Recommendation Report for Planning Permission for Works or Extension to a Dwelling

REF NO: FP/41/21/HH

LOCATION: 17 Bala Crescent
Felpham
PO22 8LY

PROPOSAL: Single storey rear and side extension to provide family room, utility room and WC.

DRAWING TITLE
PROPOSED GROUND FLOOR PLAN

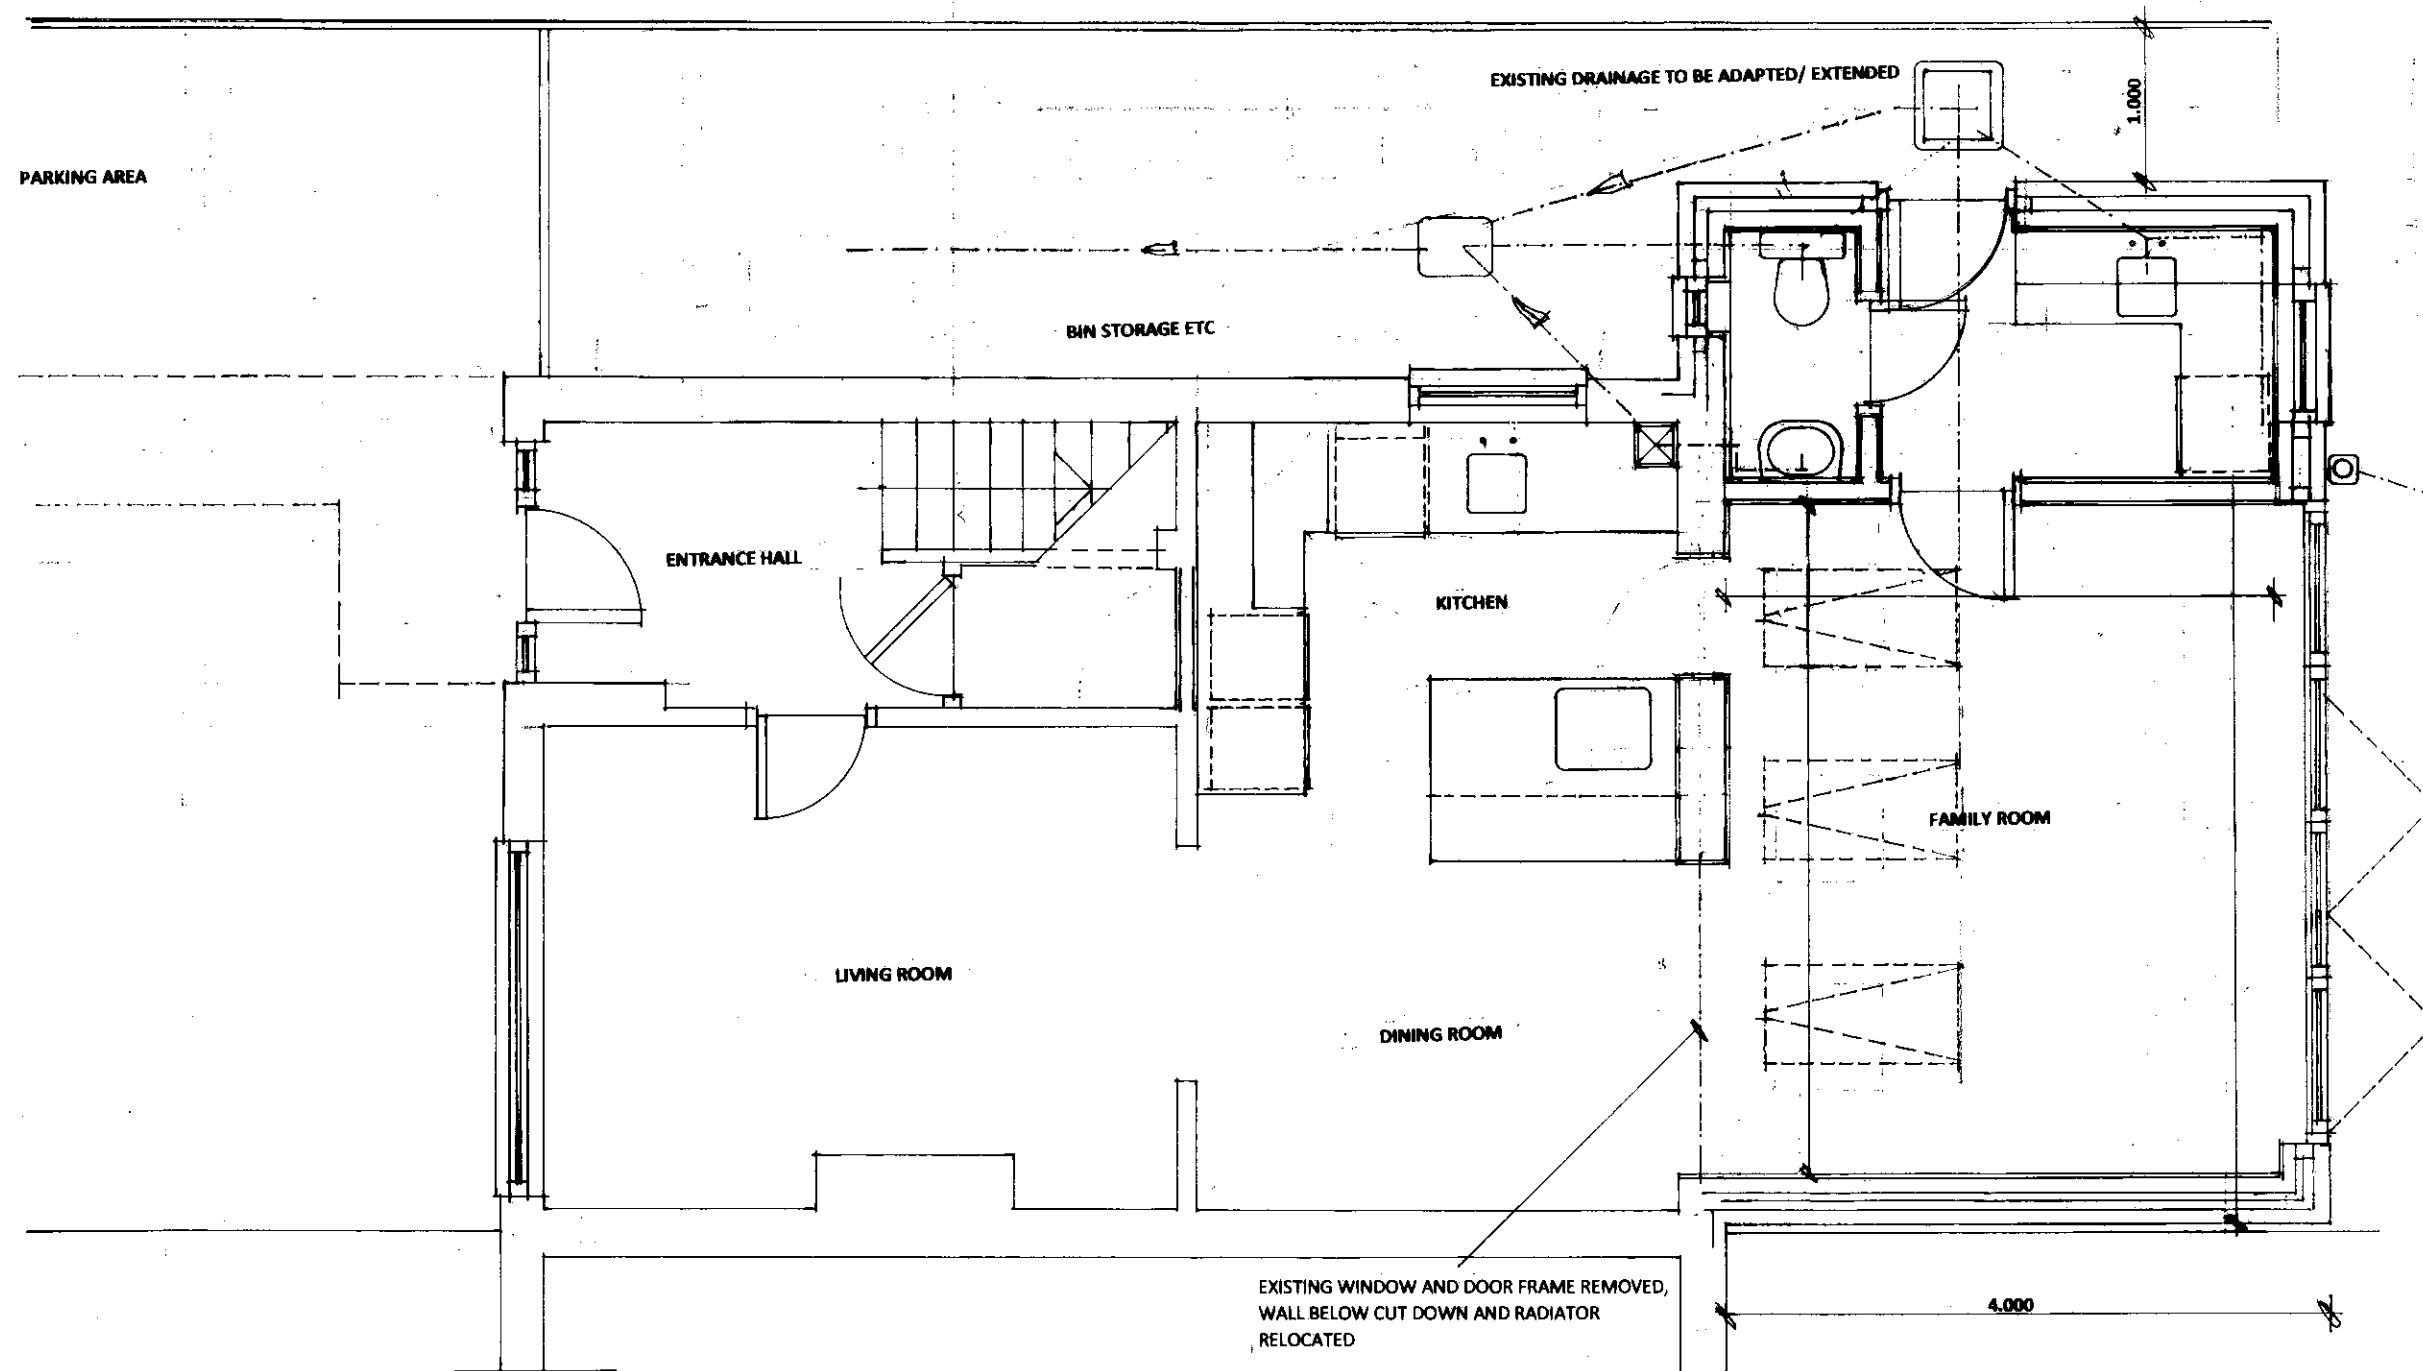
The rear extension will have a width of 6.96m and depth of 4.0m from the rear north facing elevation of existing property. The side extension will have a width of 4.30m and a depth of approximately 1.33m jutting out from the western side elevation of property. Due to the siting of extension there is 1.0m remaining to the western side boundary of property. The extension will have a pitched roof design that is in-keeping with existing property and will contain 3 roof lights. The extension will have bi-fold doors on the northern elevation facing the garden and a single door on the west elevation of extension. There will be a new window on the northern elevation and one on the southern elevation of extension facing the driveway.

Due to the siting of the proposed development it will leave approximately 18.6m to southern boundary of property, 11.0m to rear northern boundary of property, 1m remaining to western boundary and 0m to eastern boundary of property. Whilst there is less than 1m remaining to eastern boundary, due to it being at single storey it is deemed acceptable.

DRAWING TITLE
PROPOSED CROSS SECTION

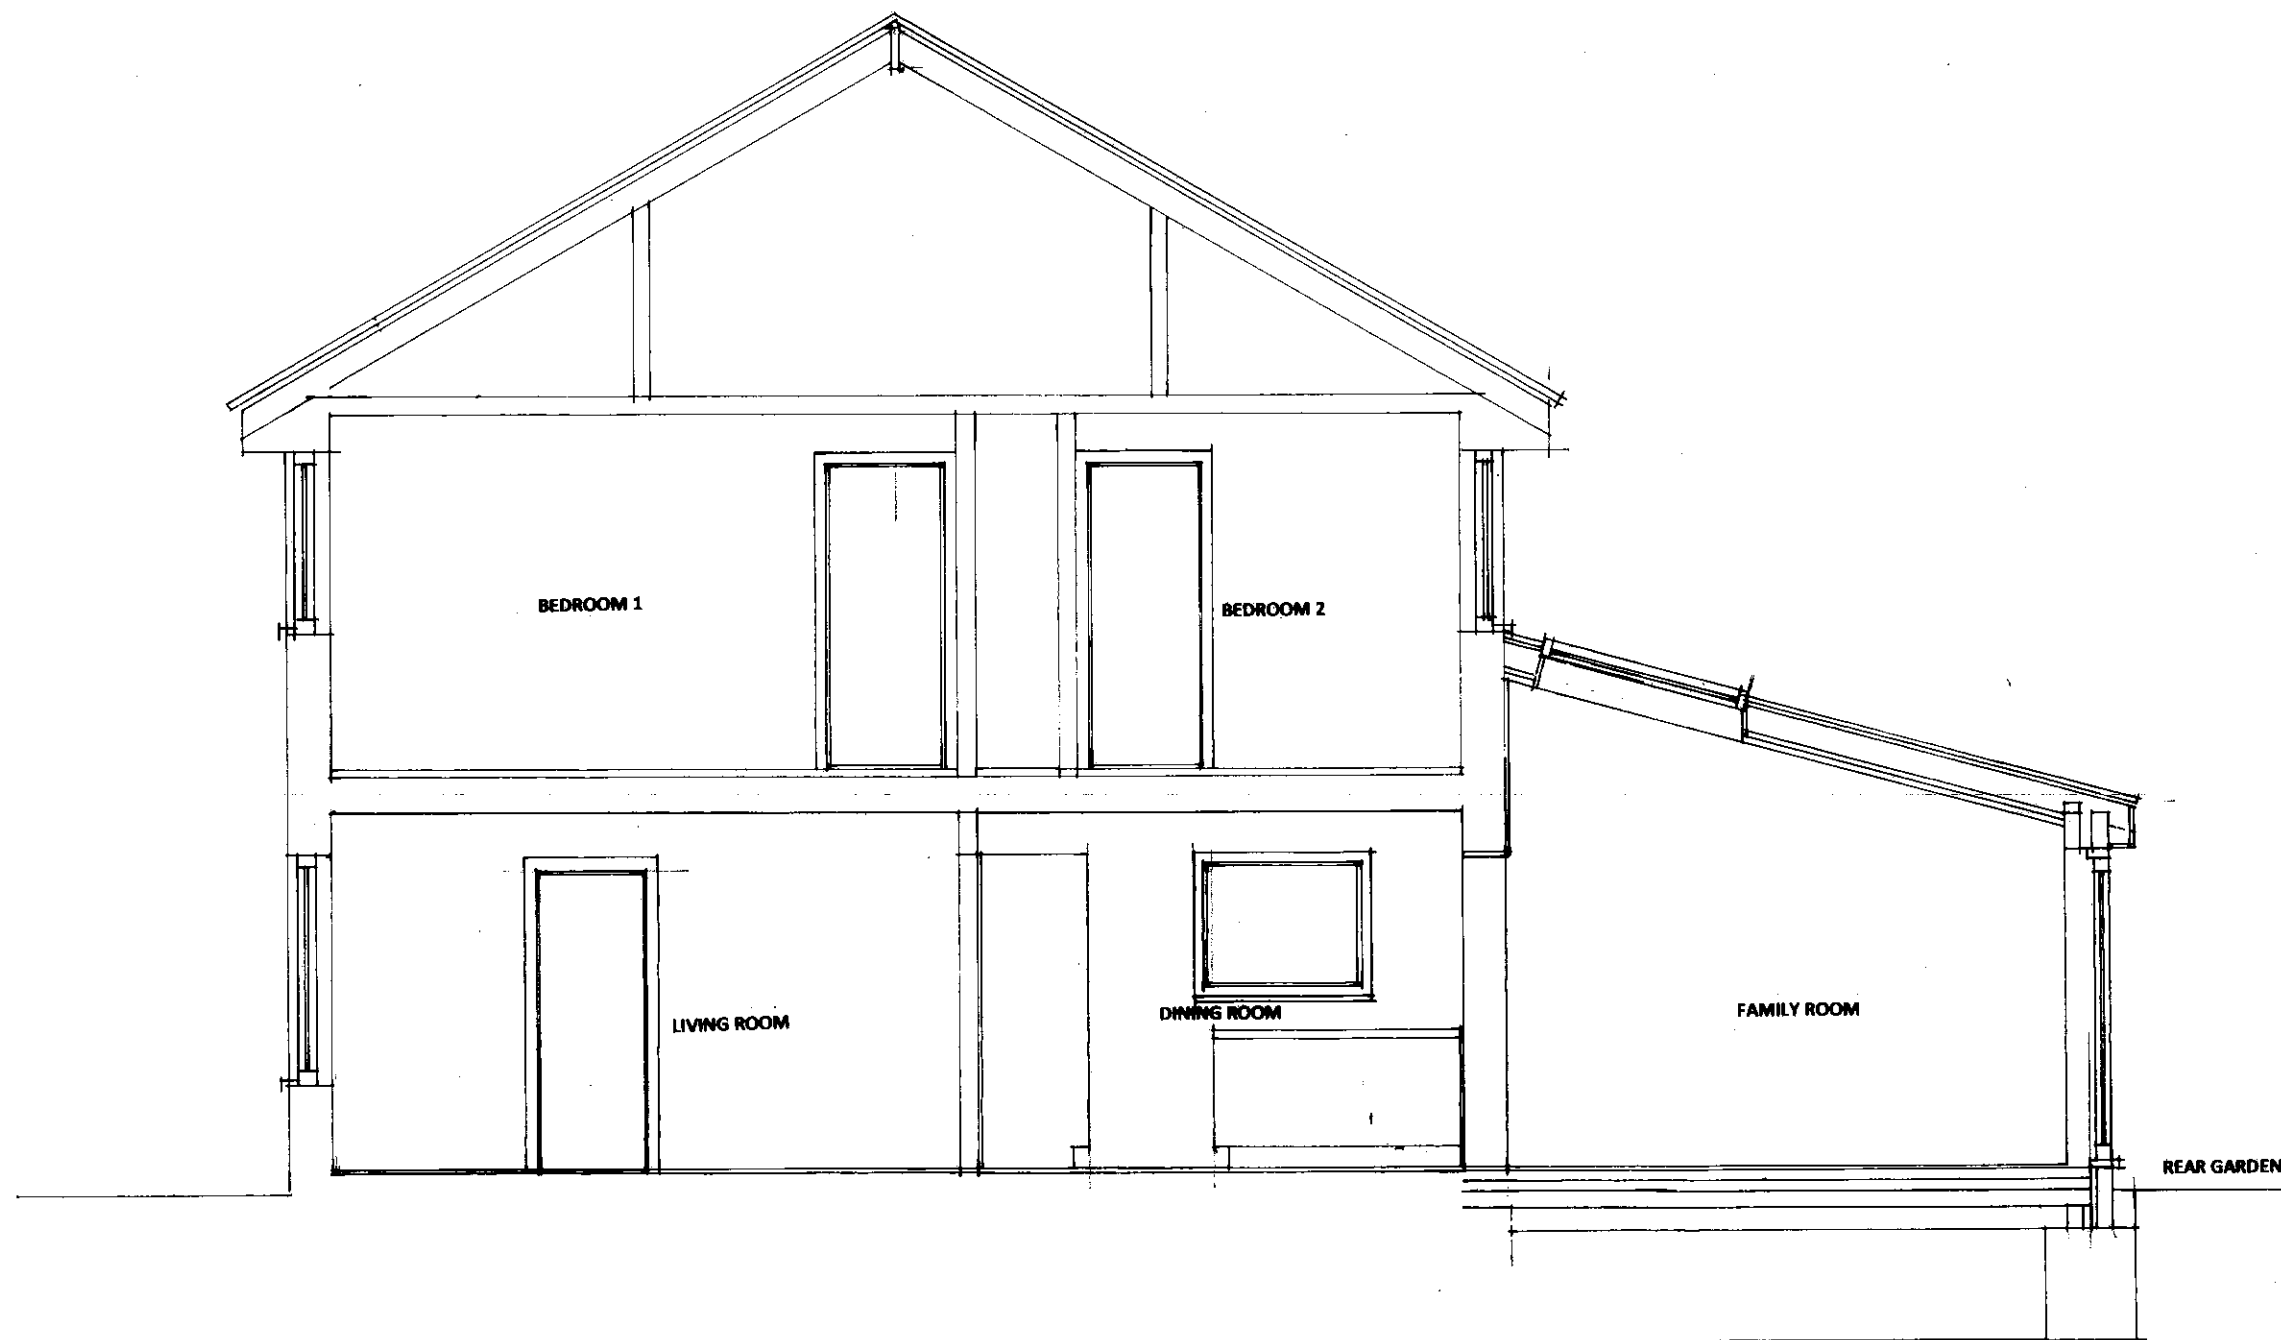
The single storey rear and side extension will have a width of 6.96m, a depth approximately 4.0m and a height of approximately 3.75m to the pitched roof. There is 1m to the western boundary of property. Due to the siting of a door on western extension elevation it will not cause overlooking to neighbouring properties due to the extension at single storey and the existing western boundary fence restricts views.

DRAWING TITLE
PROPOSED REAR (NORTH) EXTENSION

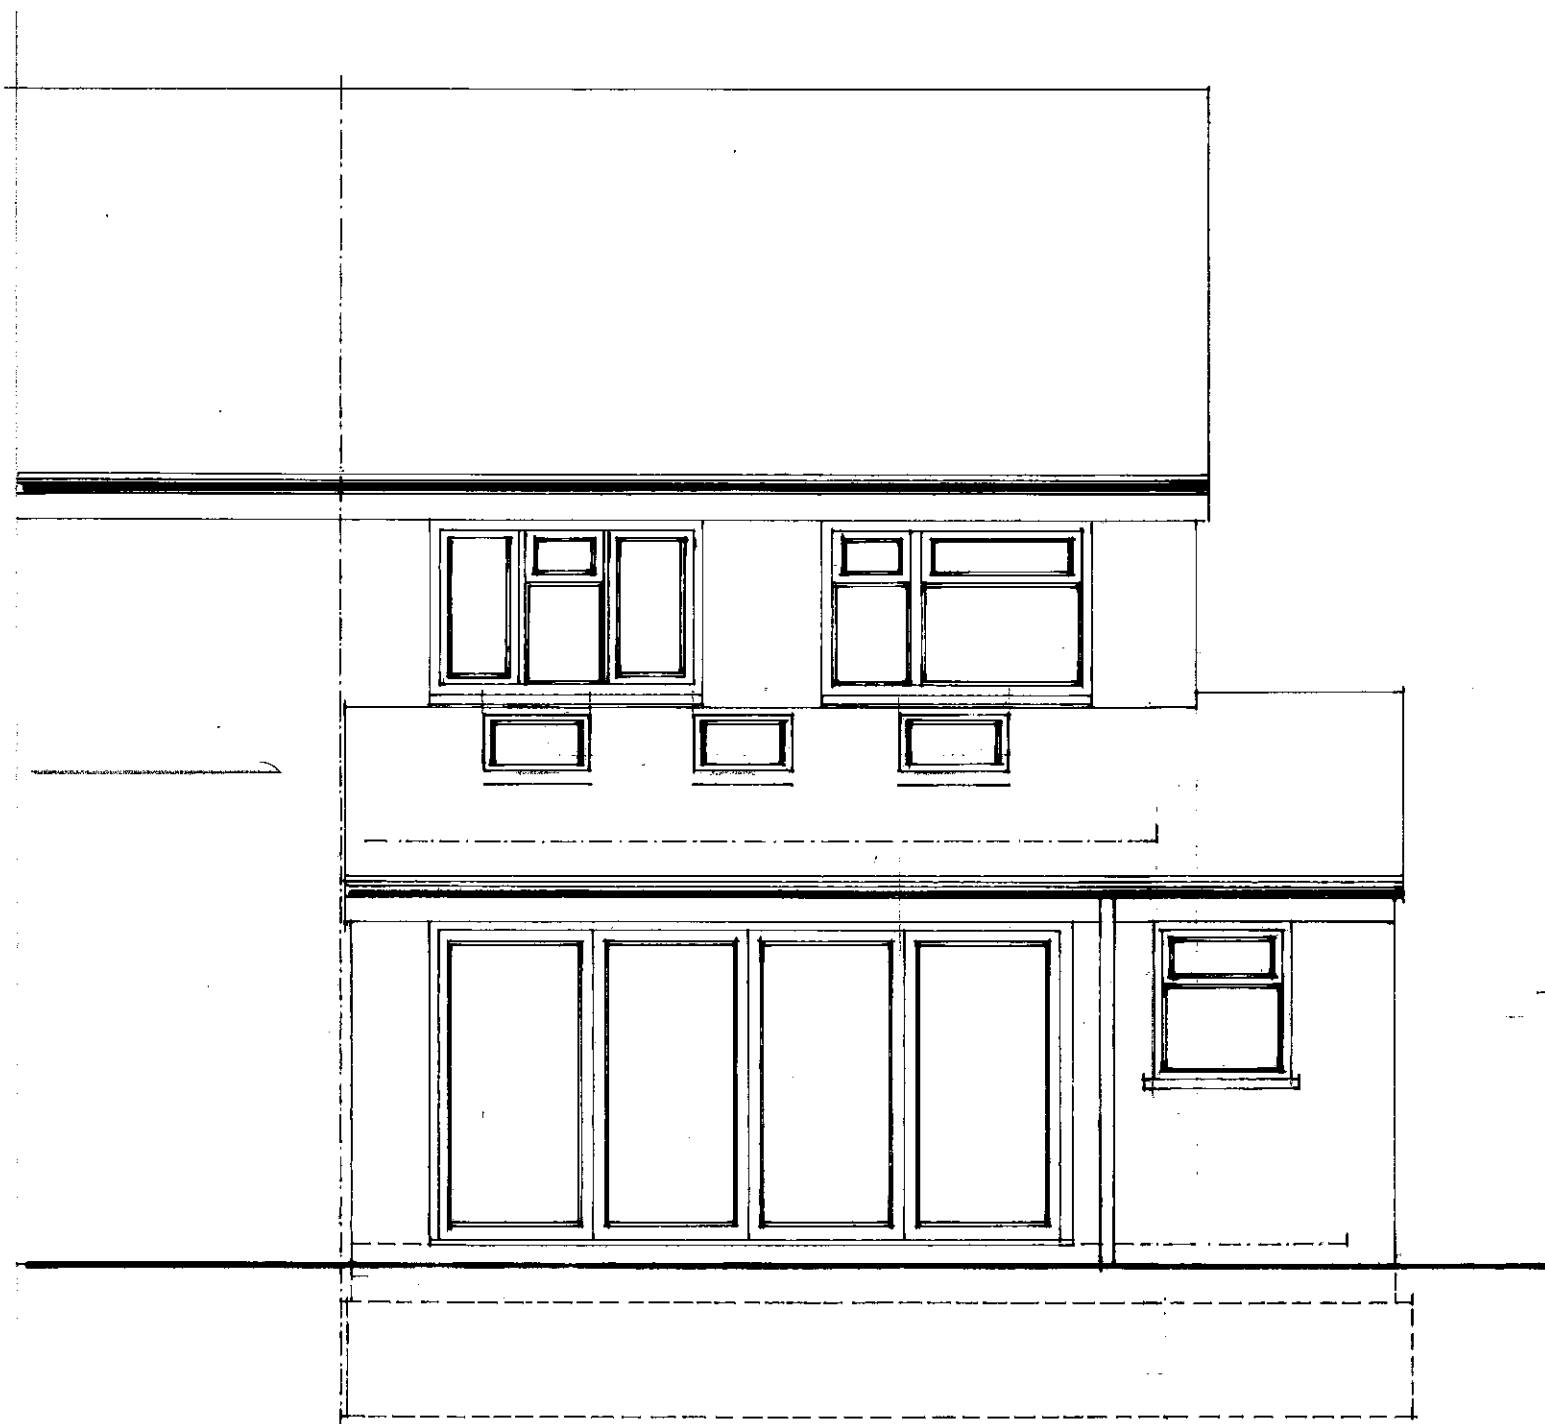
The proposed single storey rear and side extension will be visible from the street scene, although views are largely restricted due to the siting of the proposal at the rear and side of dwelling. The proposed extension will run along the rear northern principal elevation of dwelling and part way infill the western side elevation of dwelling.

The window in the southern extension elevation faces the driveway. Due to no direct neighbours to the south there is no adverse impact to overlooking to the street scene. The new proposed bi-fold doors and single window on the northern elevation of extension face the garden. Due to the large gap of 11.0m remaining to rear of garden there is no harm to overlooking to neighbours at rear of property and the extension is sited beyond existing building line to west so no harm of overlooking to neighbouring property to the west. The extension will not have adverse overlooking effects to east due to being at single storey and no windows proposed in east elevation of extension so complies with Policy D DM4 of the Arun Local Plan.
